# POST DEVELOPMENT DRAINAGE PLAN

PROJECT: WATerview NORTH  
SHEET TITLE: POST DEVELOPMENT DRAINAGE PLAN  
FROM: n/a TO: n/a  
JOB NO.: 02-19-05 SHEET: 3 OF 3

PRE-DEVELOPMENT BASIN MAP

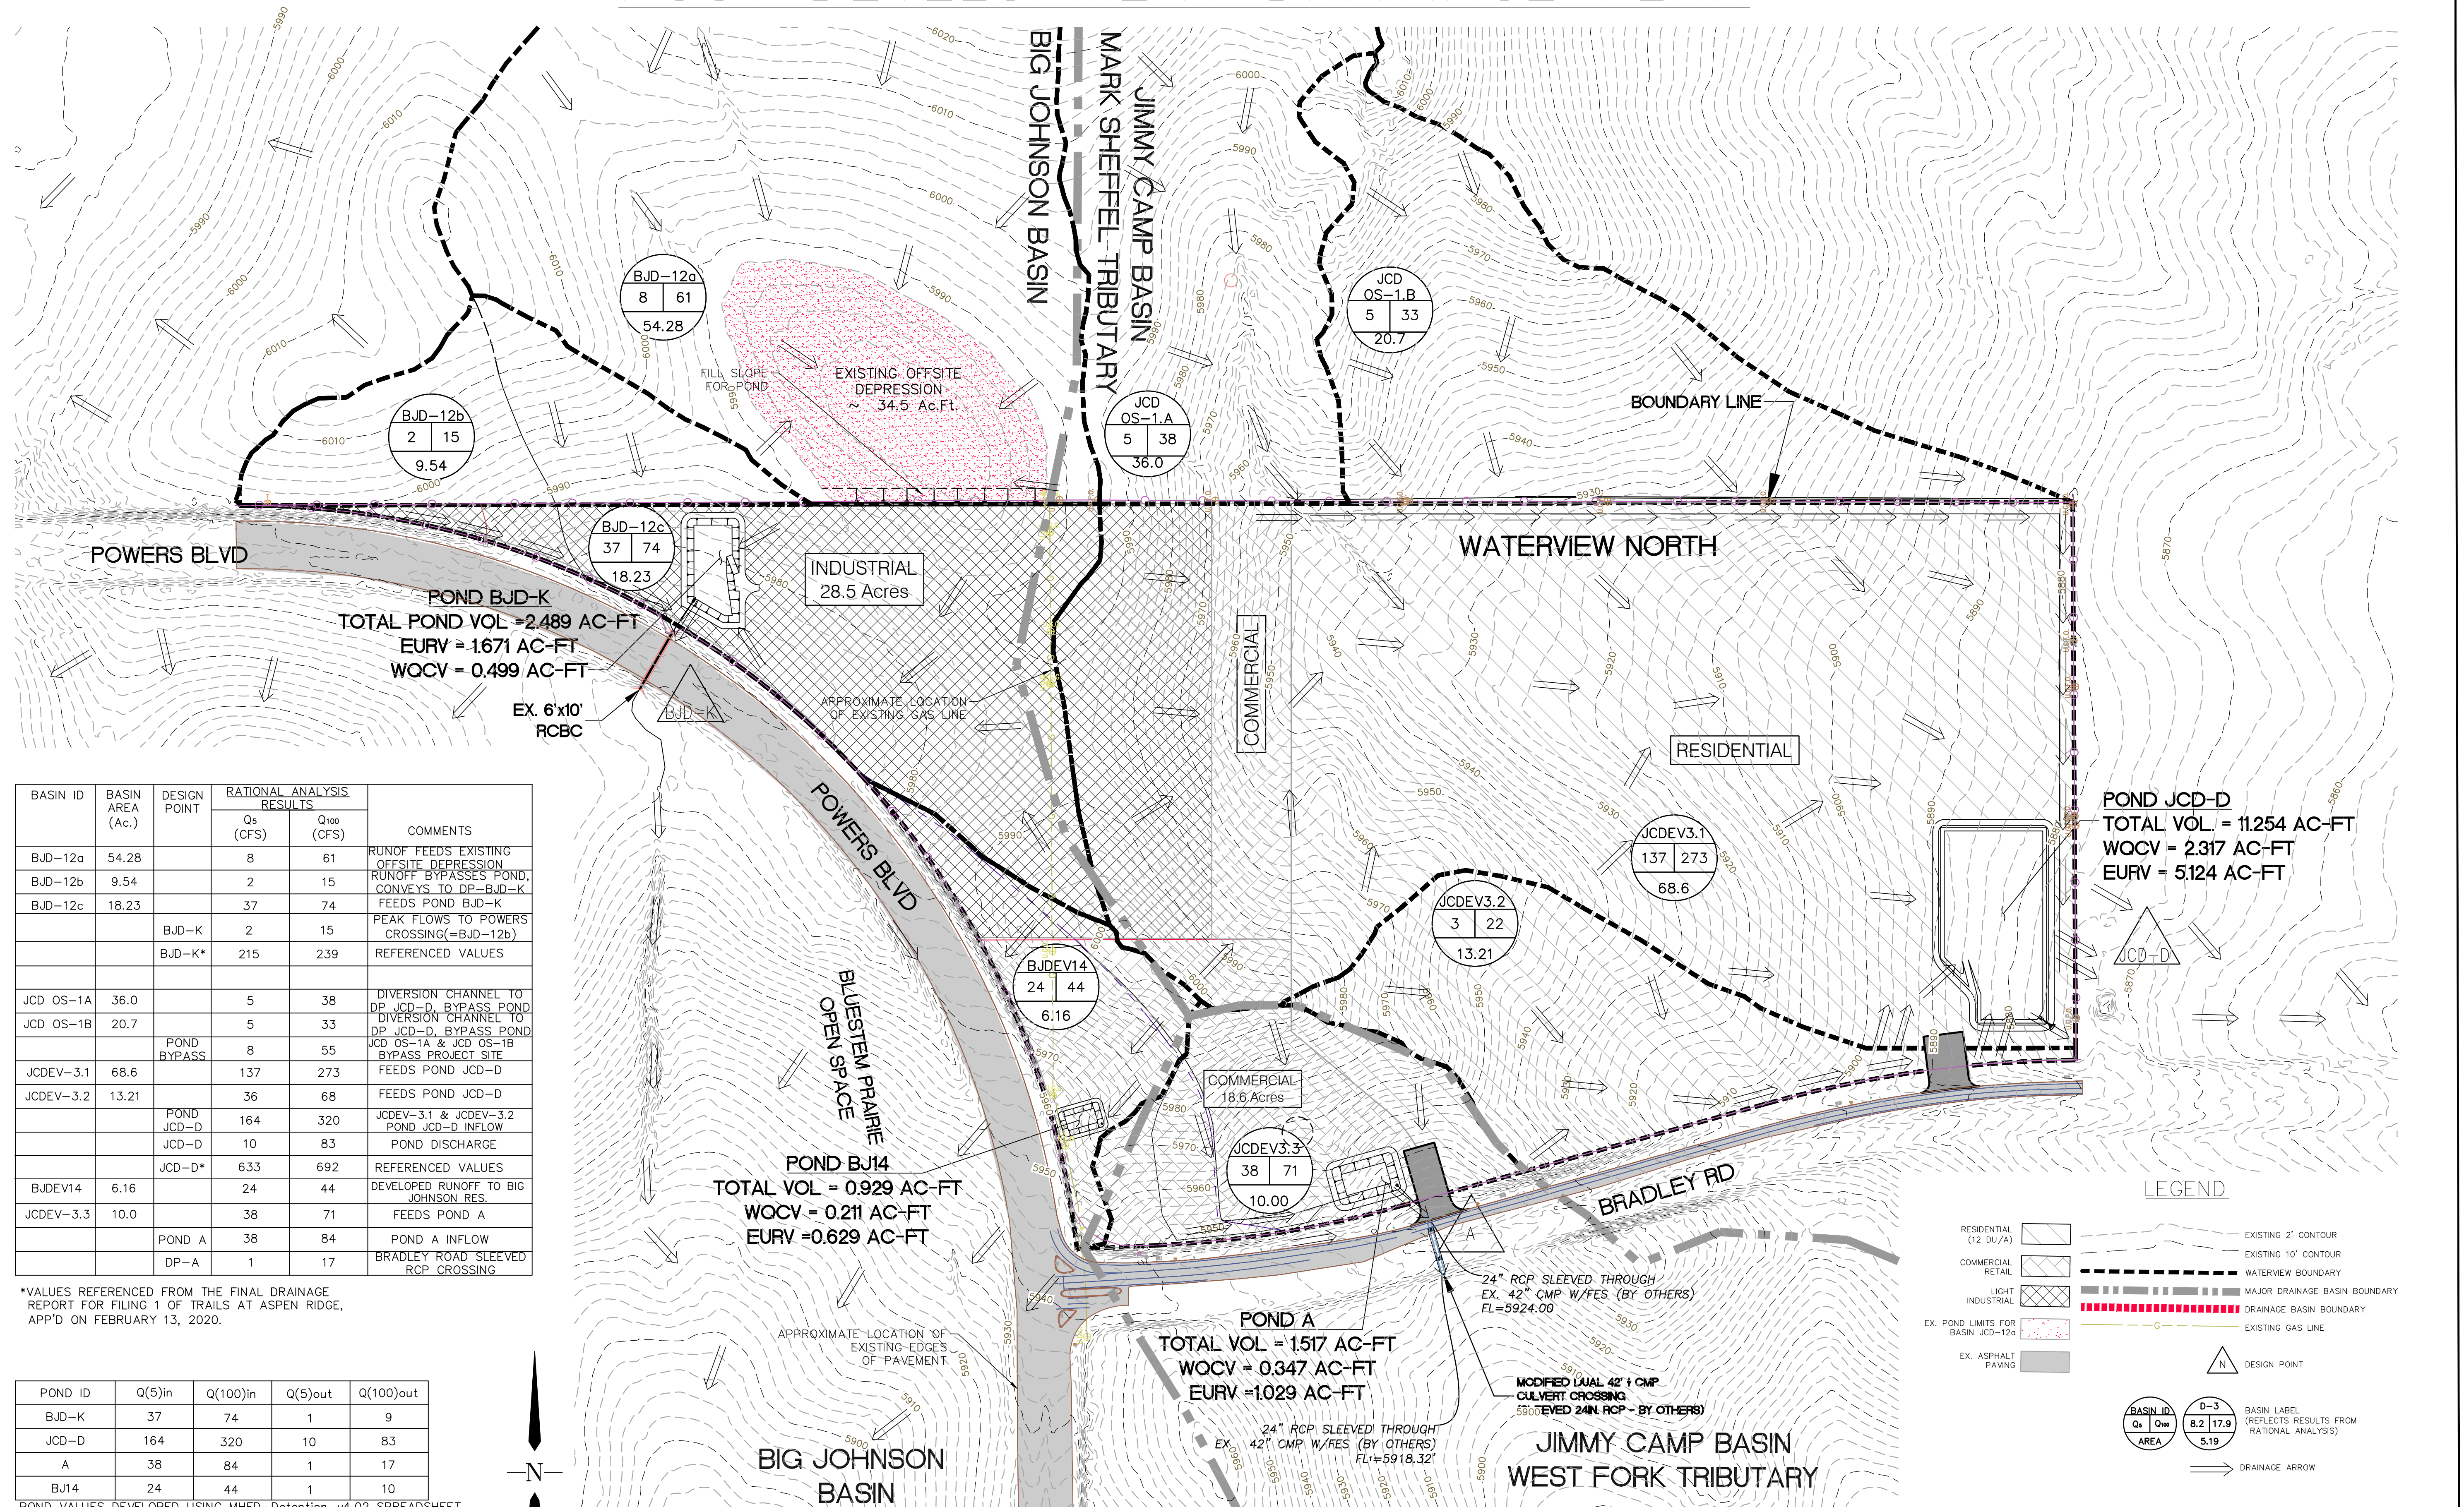
Flow at DP JCD\_D must be equal to or less than historic. The pre-development map notes (12 and 84 cfs) Update drainage design/pond release.

Unresolved. Over-detention may be required on the pond so the total combined discharge from the bypass flow and pond is equal to or less than historic. Snippet below is from the pre-development map.

DSE Response: Updated chart to appropriate flows
